Phone: 0300 123 6780  
Email: [developeras@lancashire.gov.uk](mailto:developeras@lancashire.gov.uk)  
Your ref: 03.25.0929  
Our ref: 03.25.0929  
Date: 16.01.2026

**Planning Application No: 3/2025/0929**

**Proposal: Change of use of the existing dwellinghouse (C3) to a small children's residential home (C2).**

**Location: 17 Redwood Drive Longridge PR3 3HA**

Proposed Site Plan
1:50 Scale

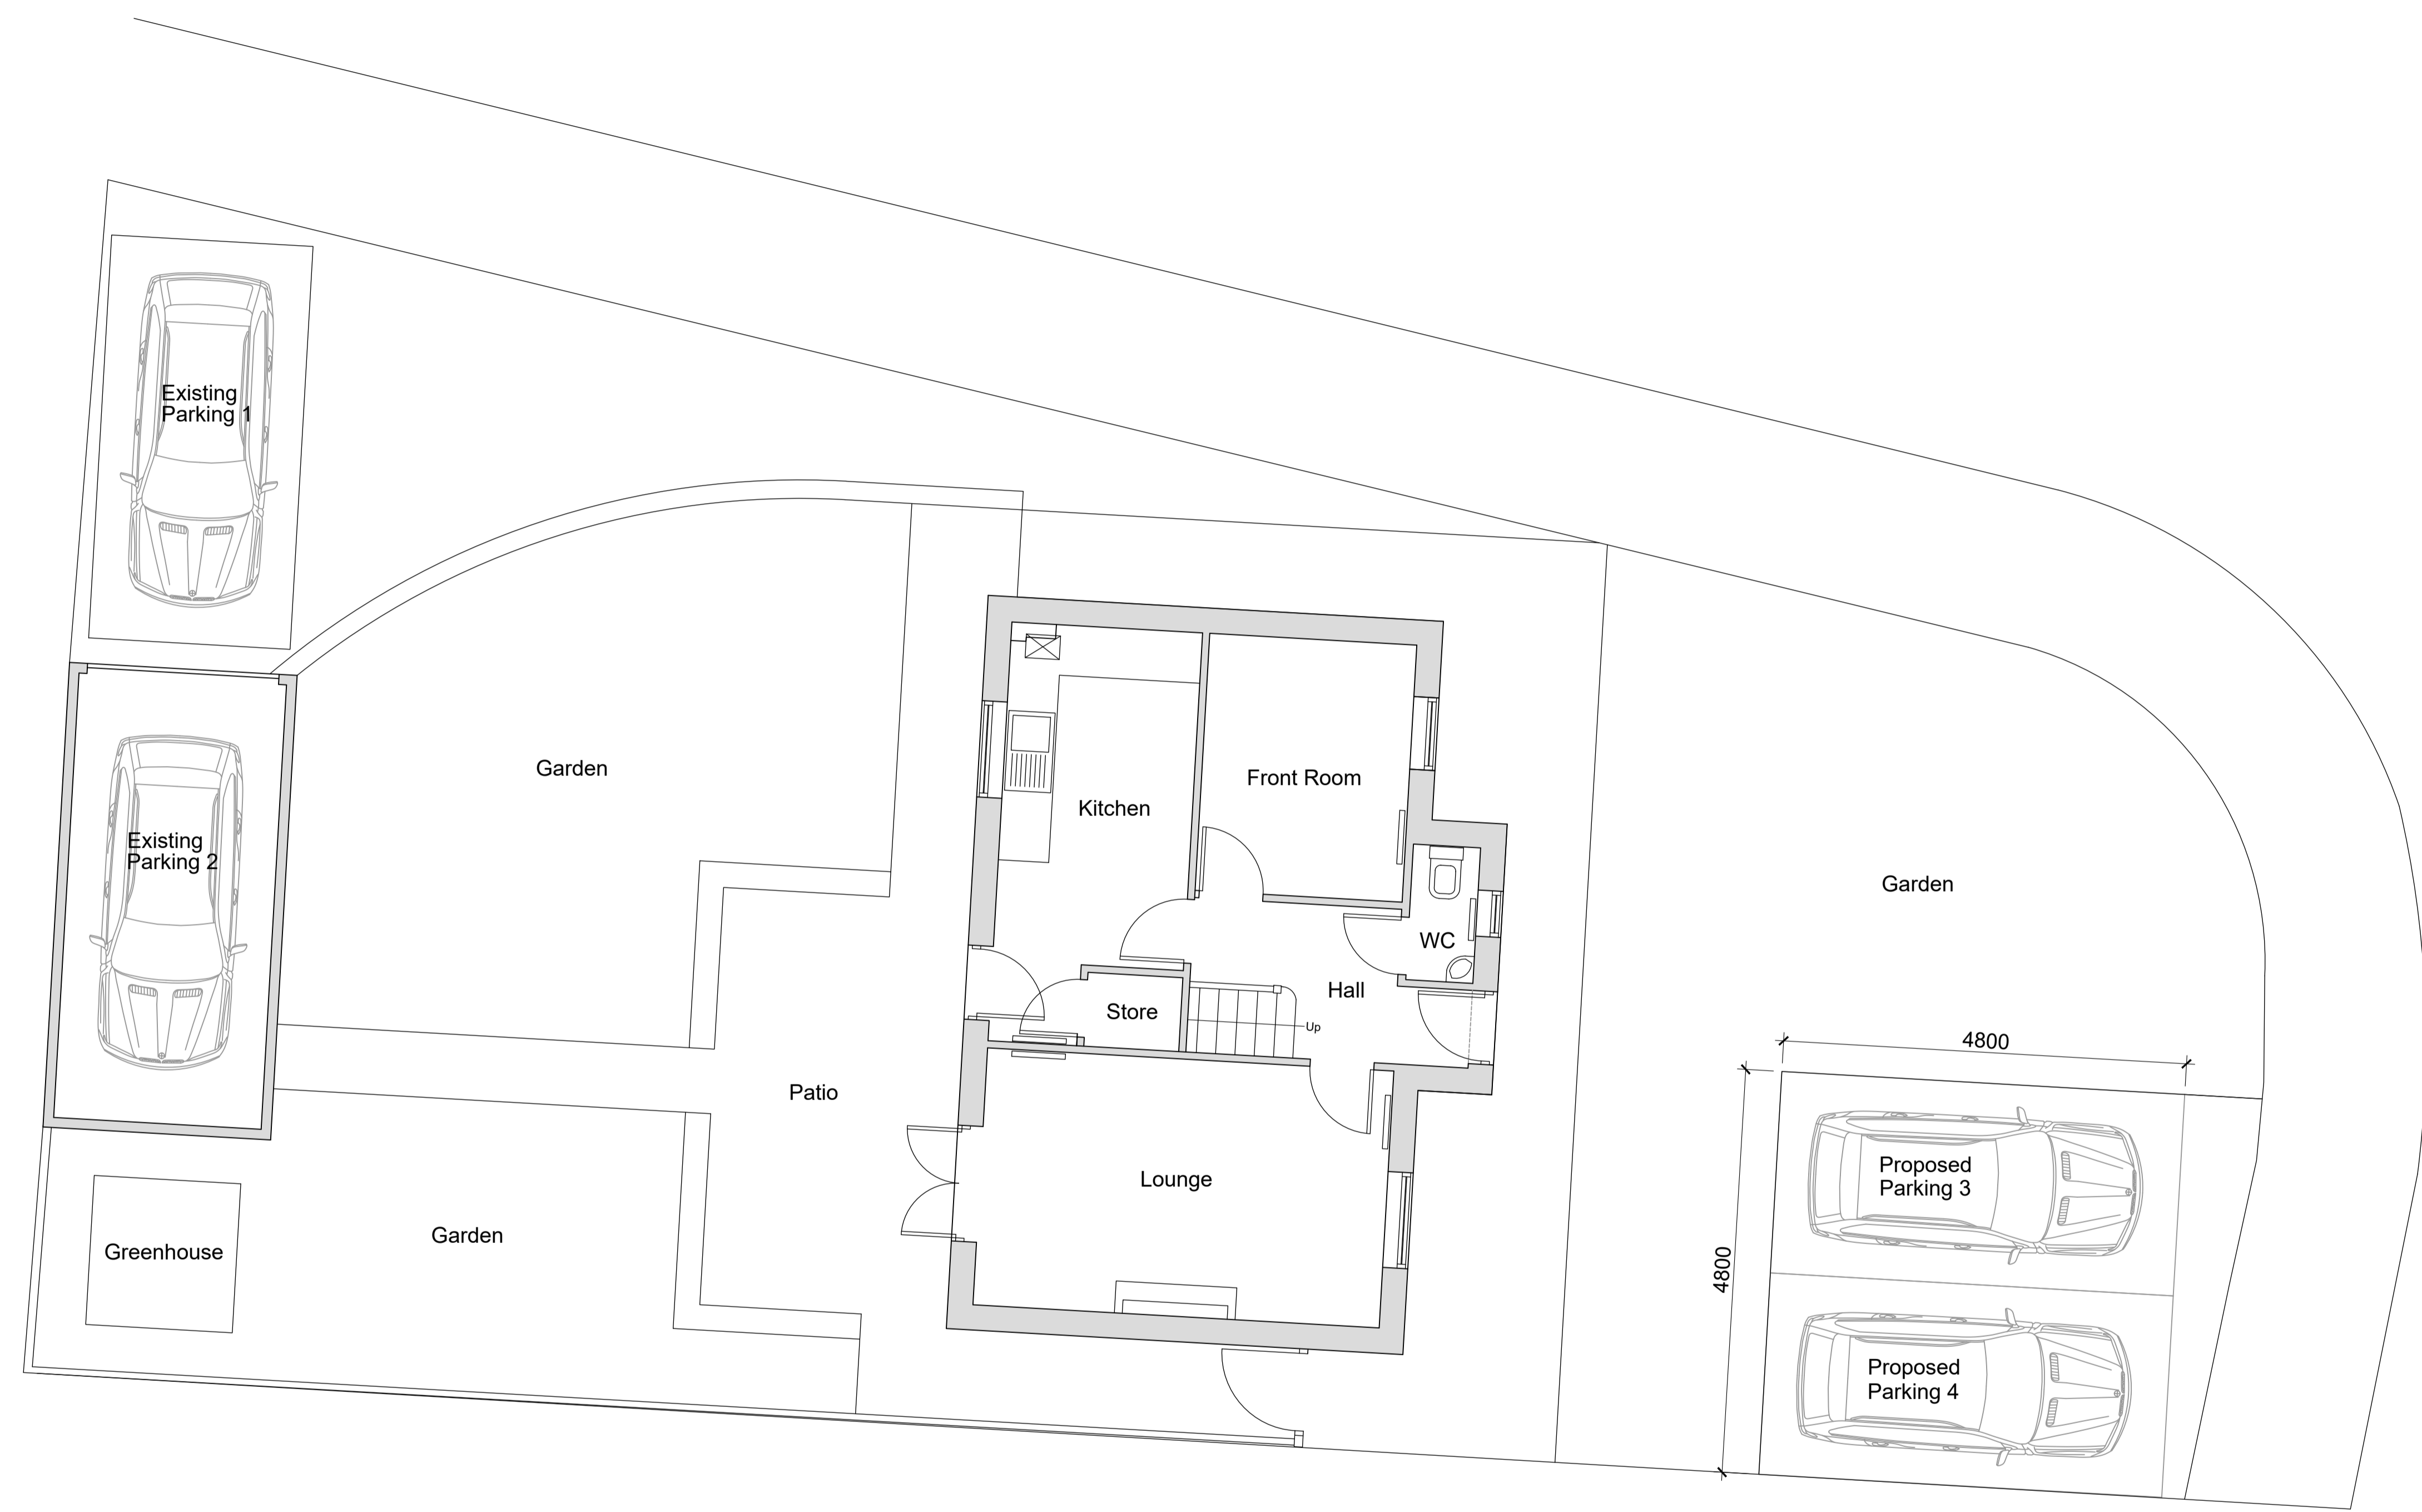
- The development hereby permitted shall not be occupied or brought into use until the Proposed Site Plan submitted showing 4 car parking have been provided in full and are available for use. The car parking shall thereafter be kept available for

the parking and manoeuvring of vehicles at all times. Reason: To ensure the provision of adequate car parking on site and in the interests of highway safety.

- The parking areas must be constructed of a bound porous material and created before first occupation up until the lifetime of the dwelling existing in its proposed state. Reason: To ensure that satisfactory parking is provided before the dwelling hereby permitted becomes operative.
